**Case Officer:** Andrew Thompson

**Applicant:** OxTec Developments Limited

**Proposal:** Discharge of Condition 5 (external lights/floodlights) of 22/01683/F

Date: 27 June 2022 Drawing No.: D46581/PMU/A

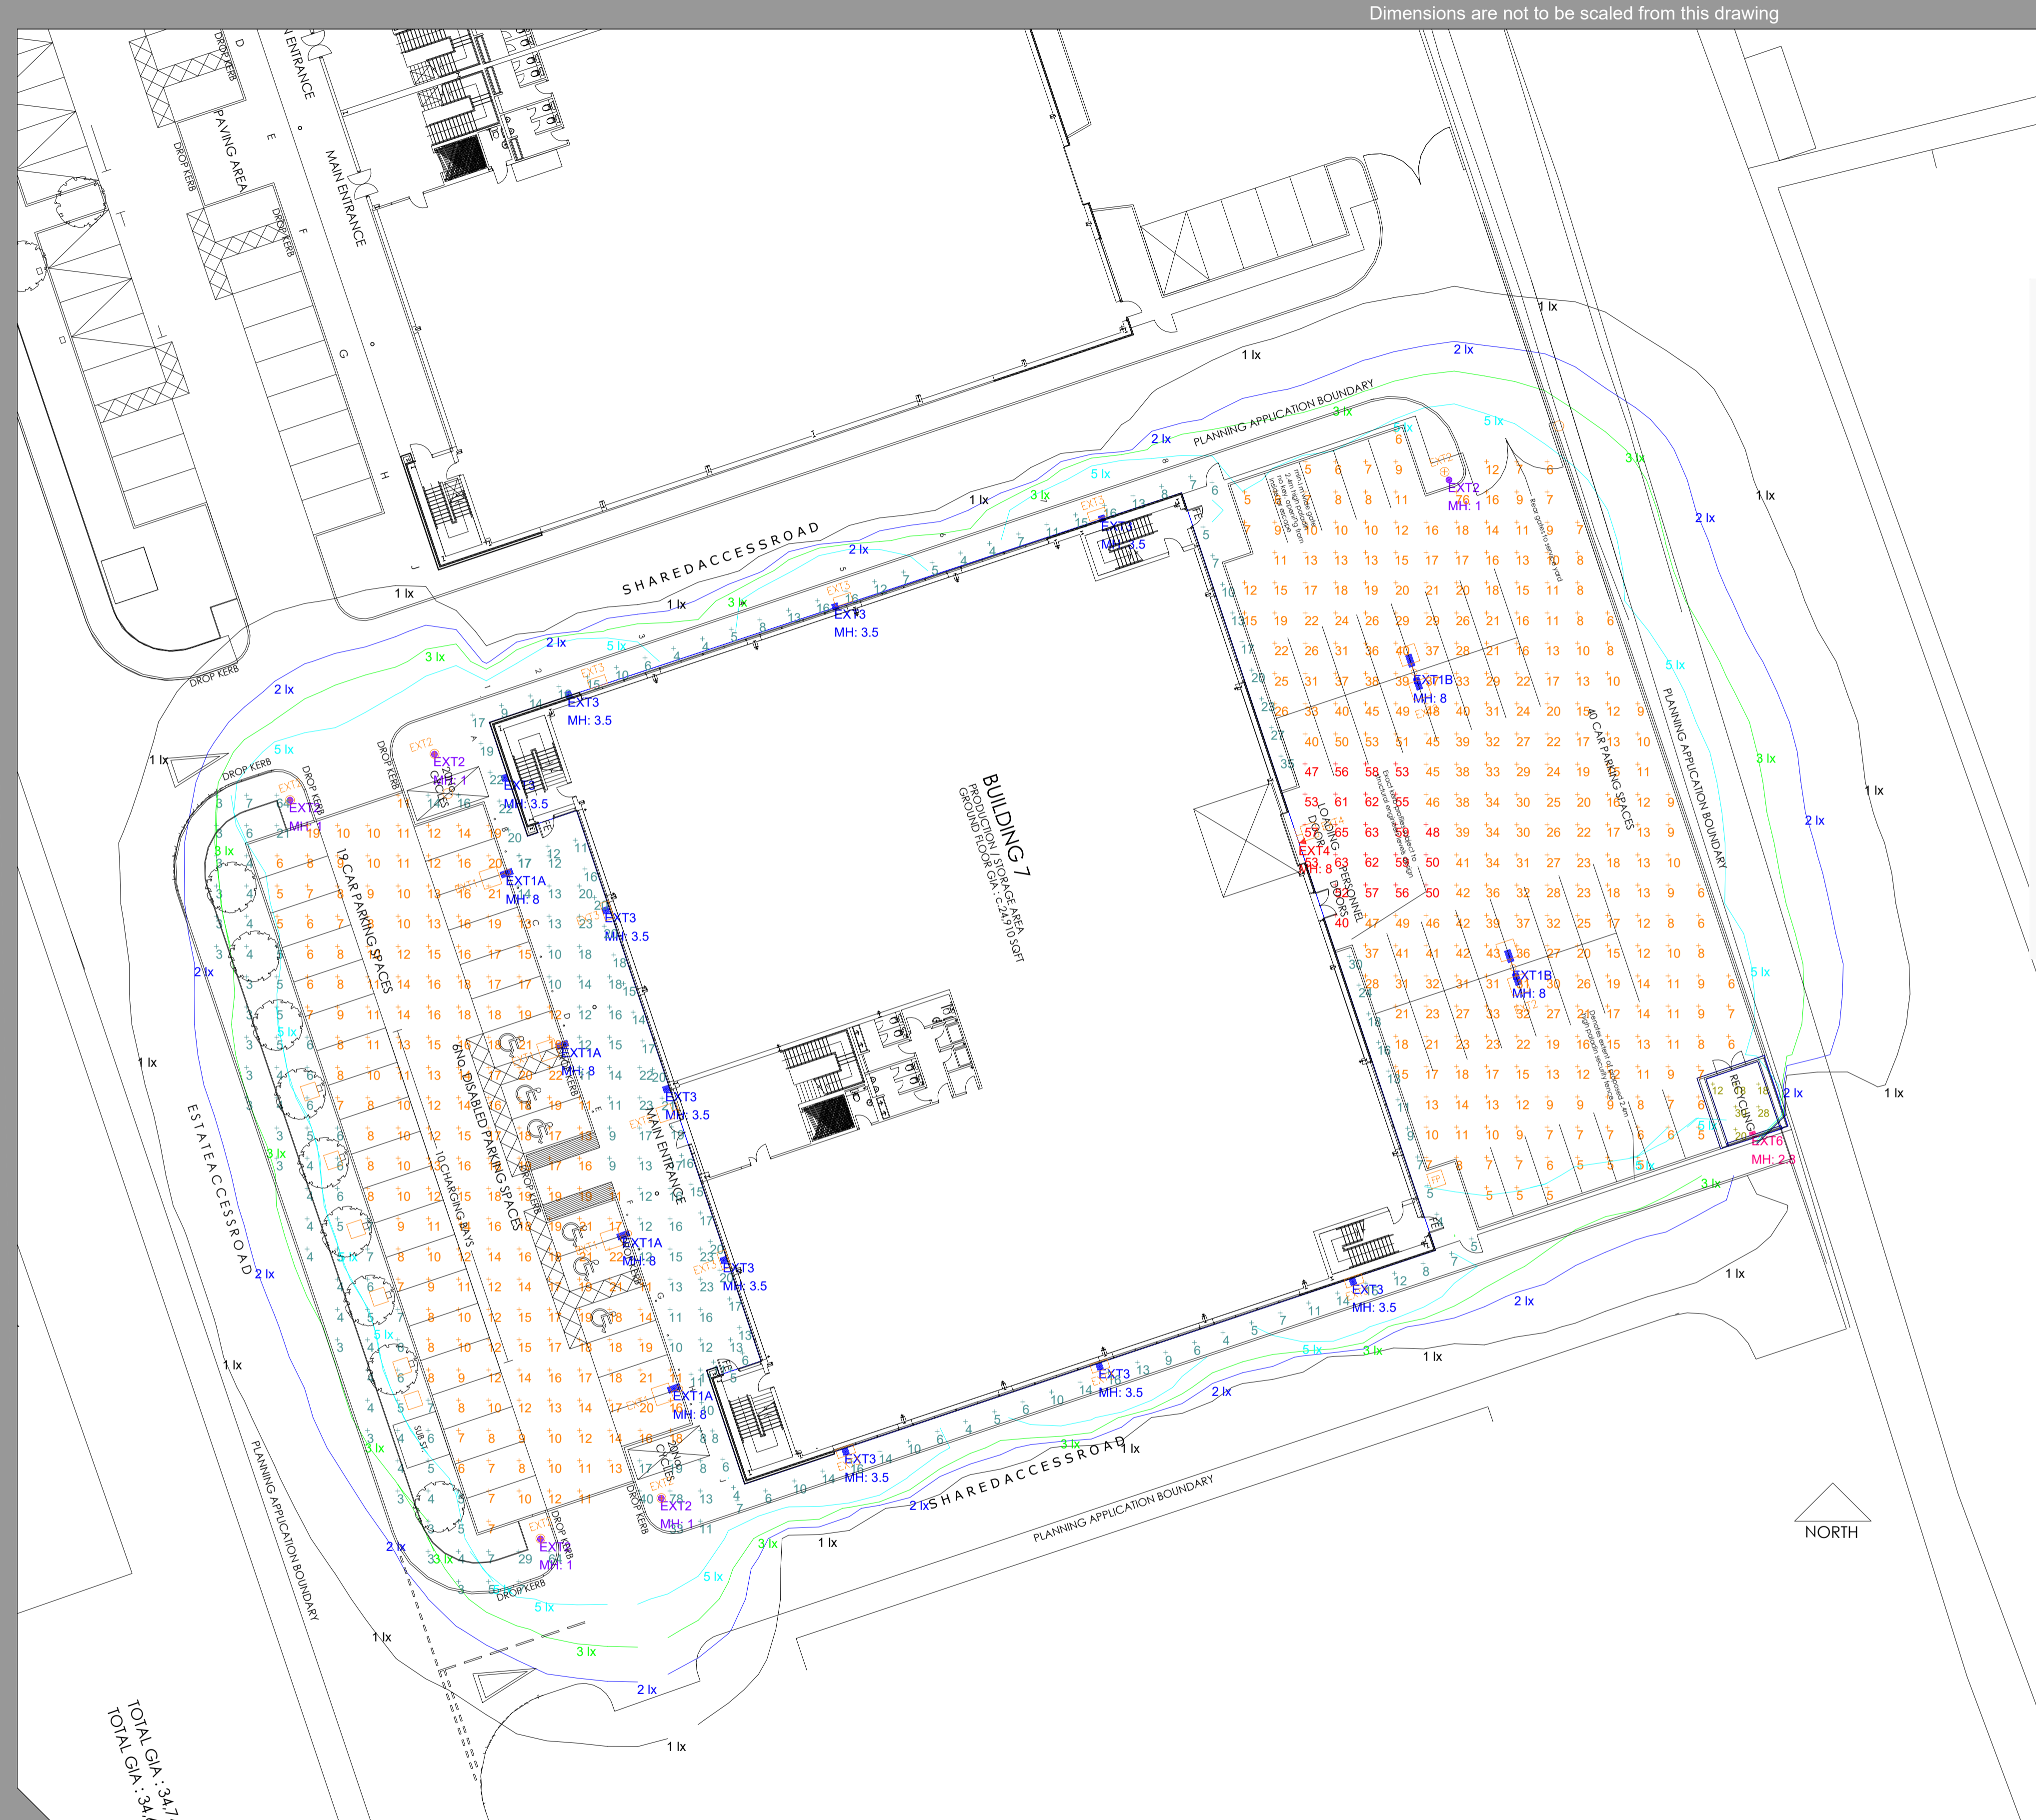
2.2. The application shows six types of lighting shown on Drawing No D46581/PMU/A  
4no. 40w LED 4000k (2 module) 700mA Italo 1 with S05 Optic – Mounted on pole at 8m

2.3. The submitted plan shows light spillage from the proposed lighting and that this would not extend beyond the site.

6.1. The proposed lighting would be proportionate to the scale of the building and be commonplace to a commercial setting. The proposed lighting would not result in light pollution or impact on London Oxford Airport as the proposed lighting would be pointed down and light impacts would not go beyond the site. Due to the position of this site, there are no residential receptors in close proximity. It also appears to be comparable to the lighting scheme approved relating to the hotel at the front of the

The information submitted shows lighting pointed downward and with light spillage not exceeding the site. As such subject to the implementation of the lighting in accordance with this plan, the scheme would be acceptable in respect of the condition. However the condition remains in place to prevent further lighting being installed without the prior express consent of the Local Planning Authority.
